Your Ref: OWPC24567
Our Ref: Y/74/19/PL
Please ask for:
Ms M Tomalova

Extension & alterations to main dwelling. Conversion of existing annexe to three holiday letting units

The Crickets Hoe Lane Flansham Bognor Regis

Thank you for your internet comments made on 10th October 2019 which has been recorded as **'an objection'** with the comments as follows:

Drawing P05 August 2019 Scale 1:100 @A3
Planning Drawing - Site Plan

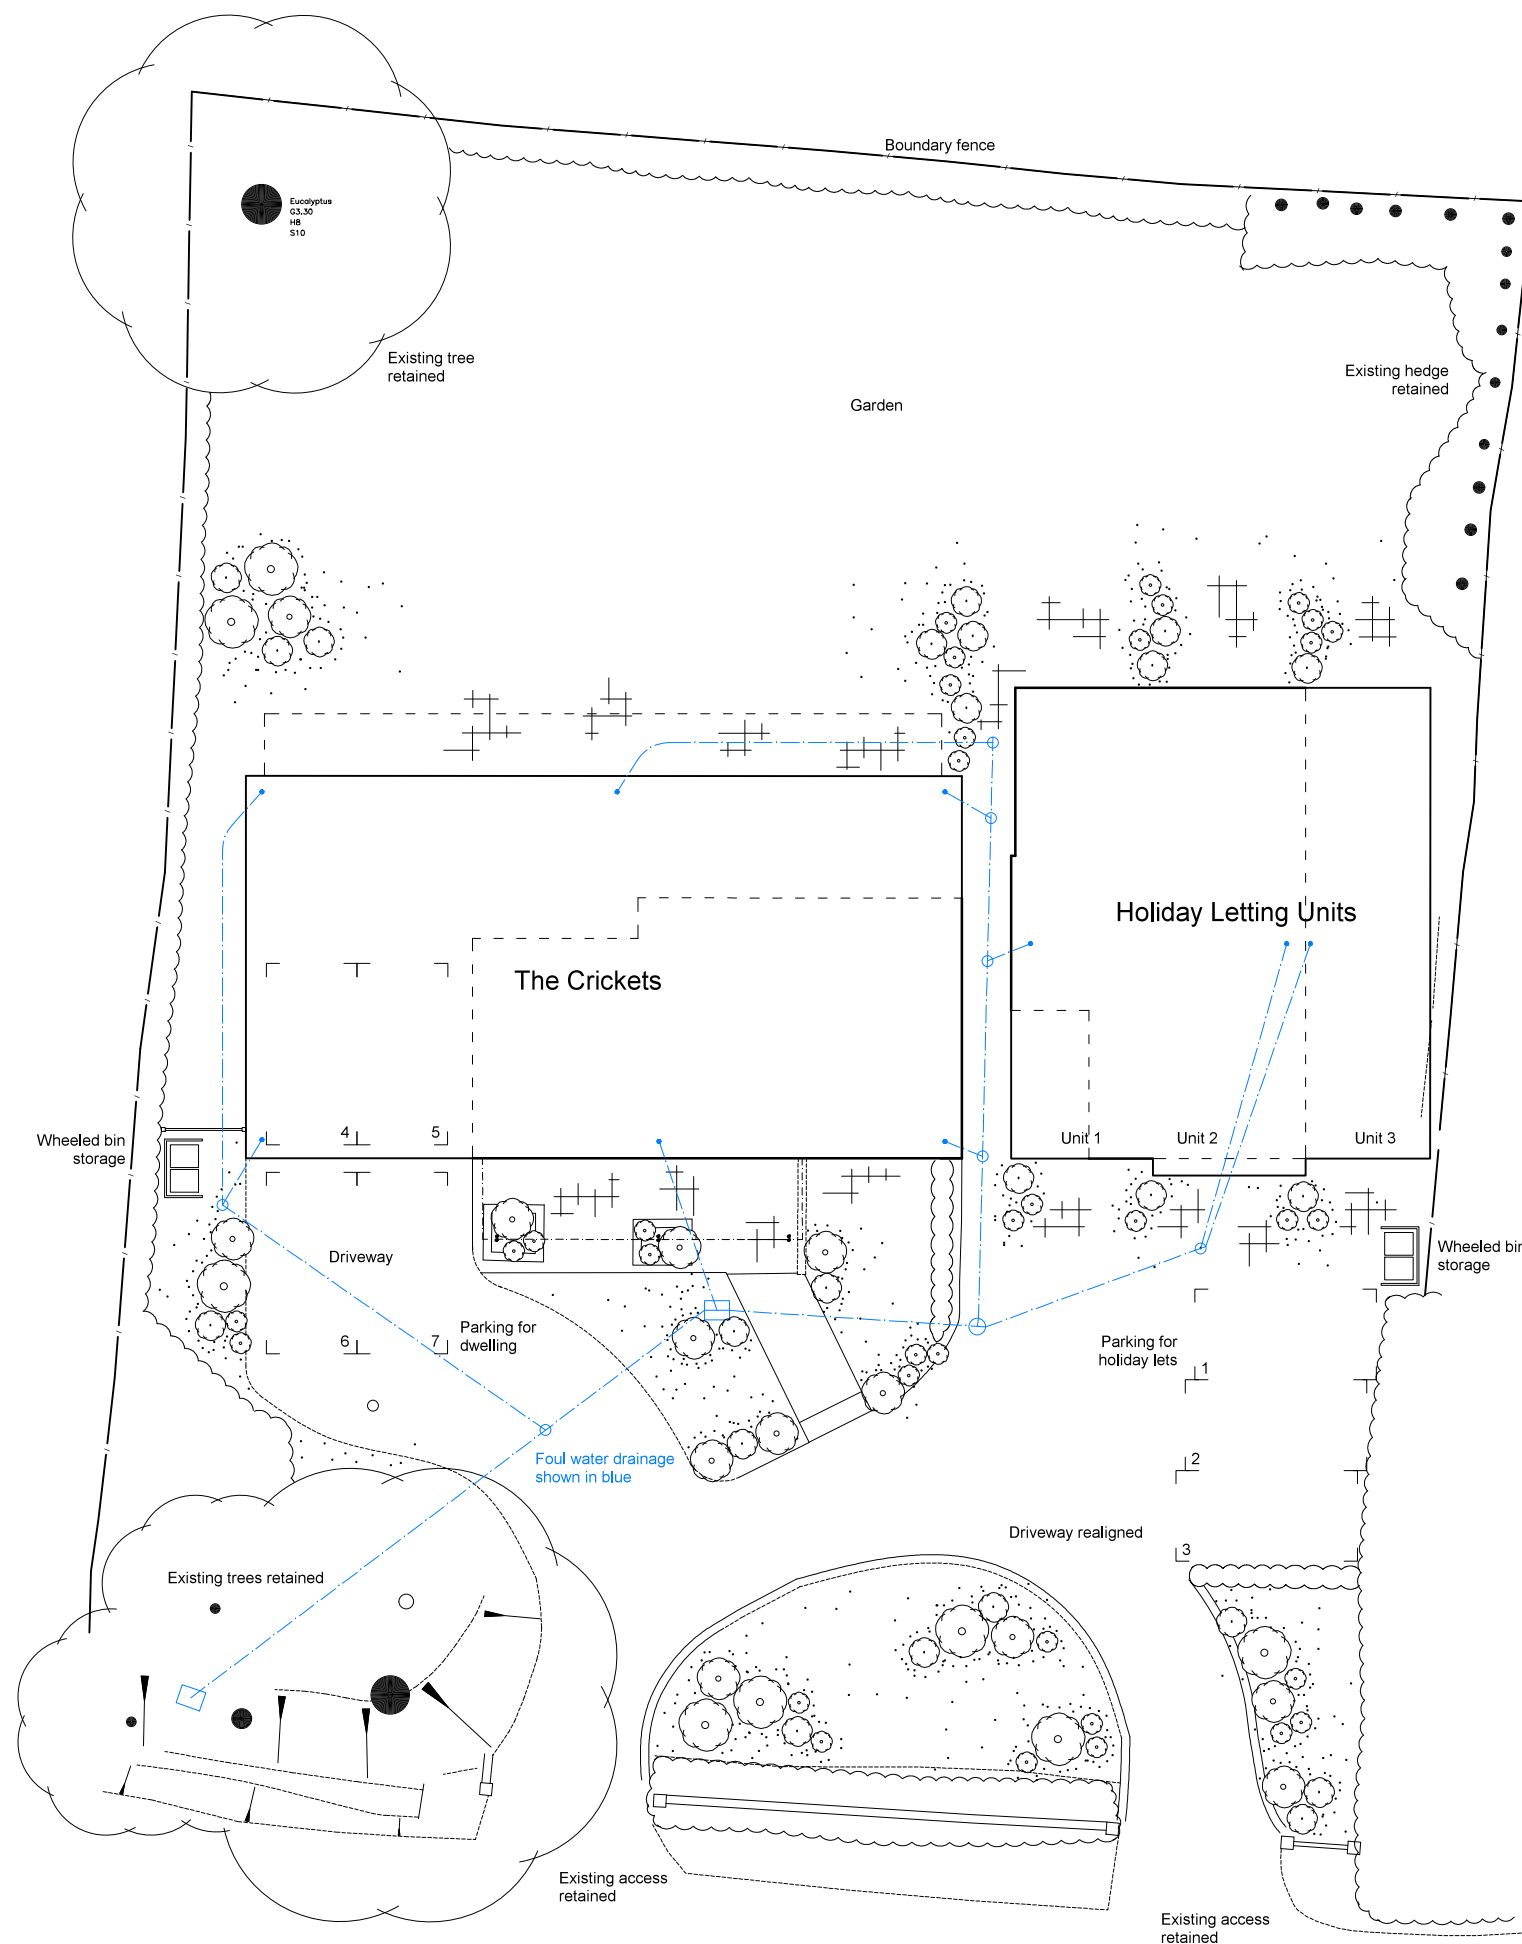
1. Over-intensive use of the site. The two proposed buildings are sited extremely close to each other generating potential conflict with the holiday let use and permanent residential use. The building line and massing of the two units will detract from this loosely developed section of Hoe Lane.

3. The proposed parking layout plan does not sufficiently demonstrate that the 7 indicated parking spaces are adequate for the whole site or that they have adequate turning and manoeuvrability space to enable cars to easily access the proposed spaces unhindered and all times. No disabled parking bay has been provided for the proposed commercial use ie holiday lets. YPC request that the viability of the proposed parking if clearly demonstrated by full tracking being submitted.

Proposed Extension and Conversion
at The Crickets, Hoe Lane, Flansham
for Mr B Brogan
Drawing P03 August 2019 Scale 1:100 @ A3
Planning Drawing - Roof Plan & NW Elevation

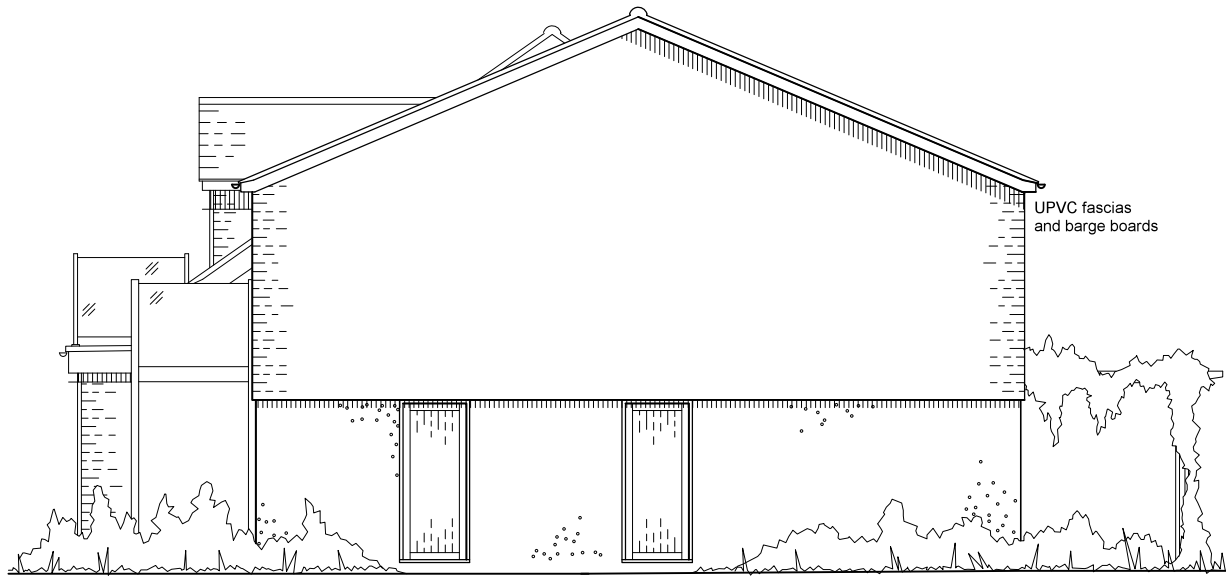
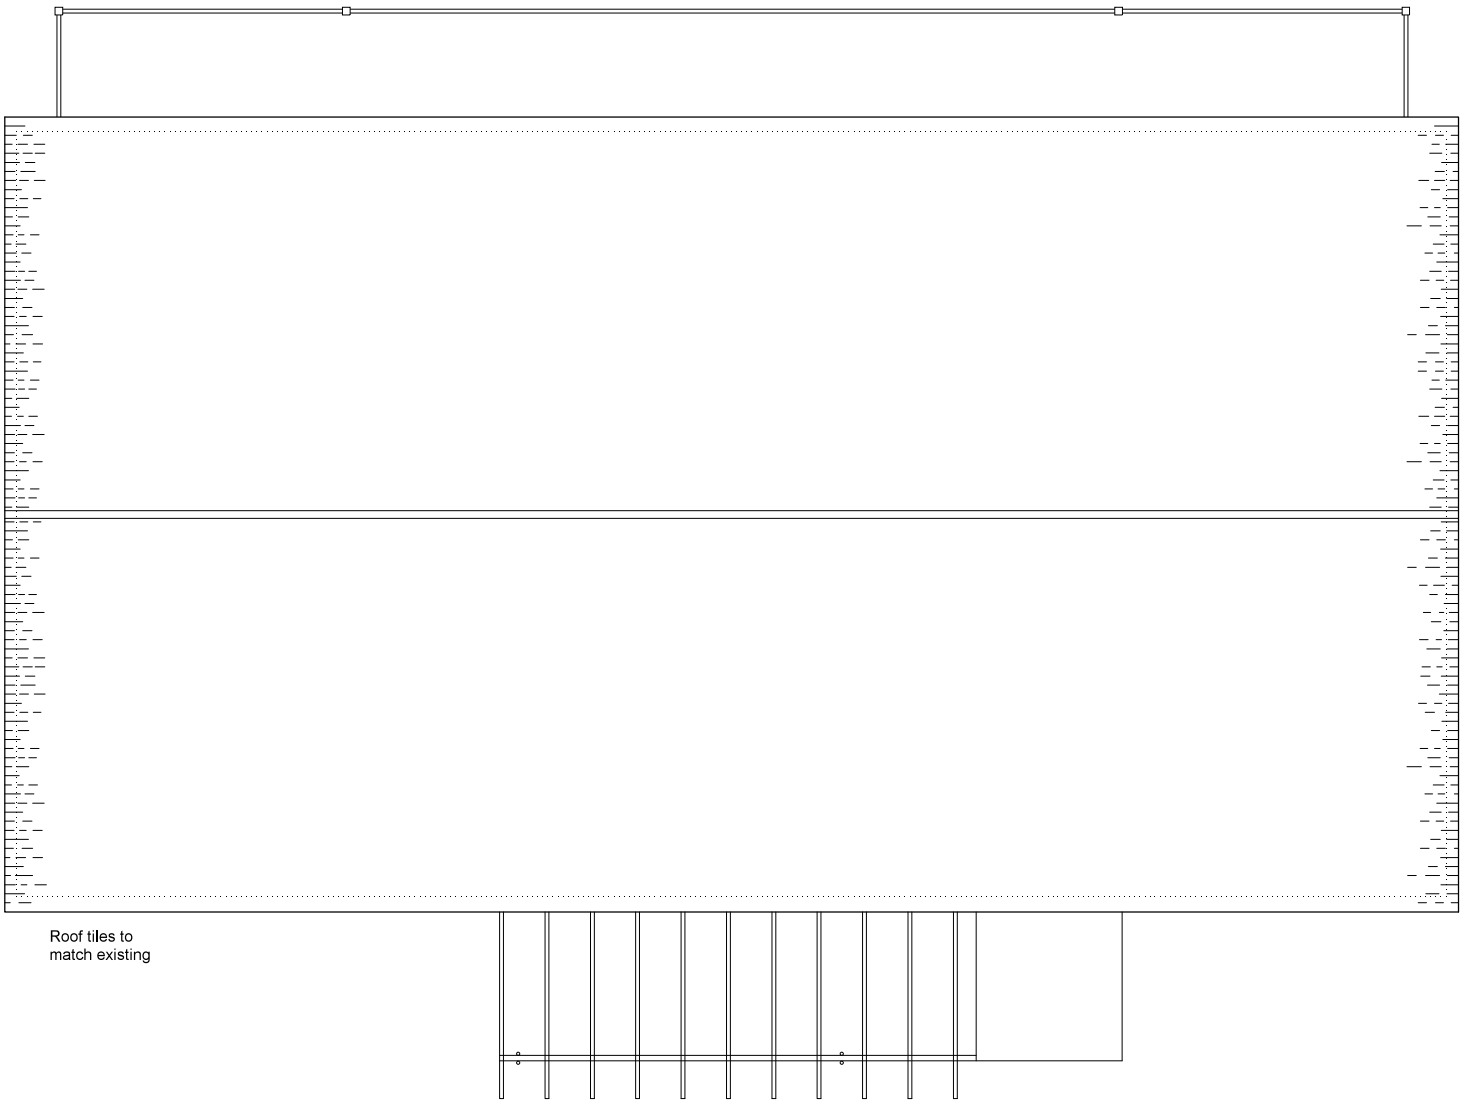
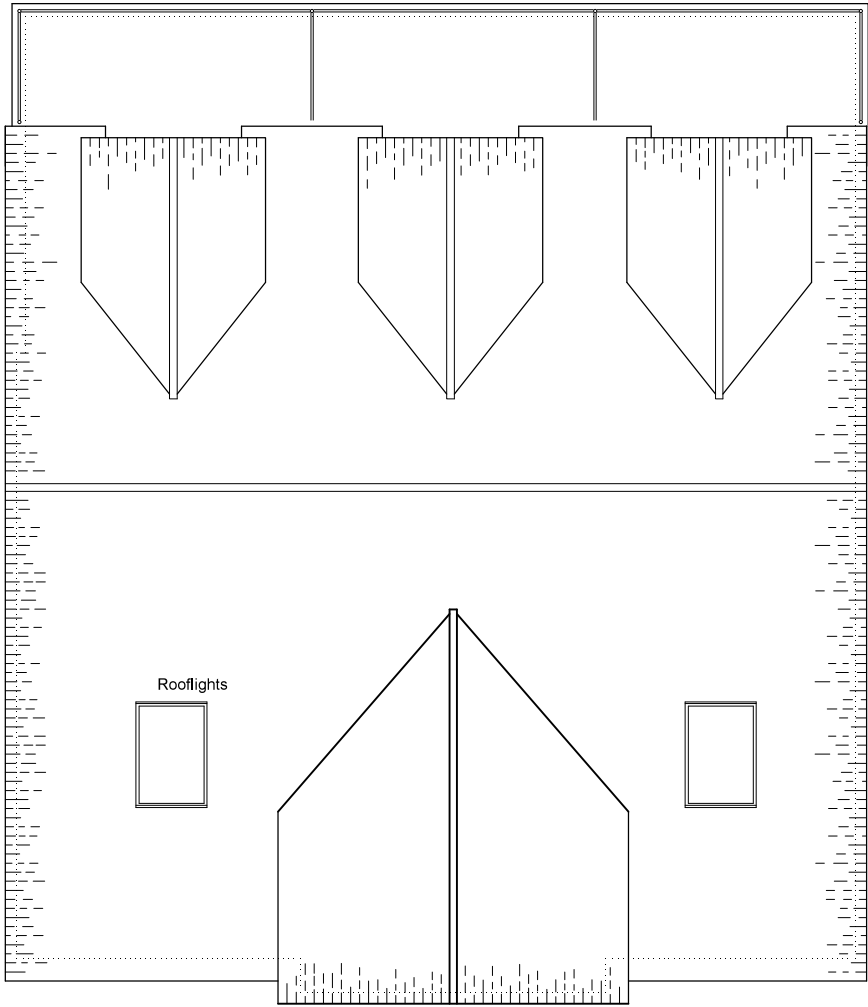
2. The proposed extension of the residential dwelling whilst large is in keeping with the current two storey structure. However, the proposed holiday lets building is a substantial departure from the existing structure's size and proportions. YPC believe that the proposed holiday lets are a significant overdevelopment of a small existing footprint and are overbearing on the adjoining residential unit. YPC would seek the proposal to be reconsidered with a less intensive holiday use proposed.
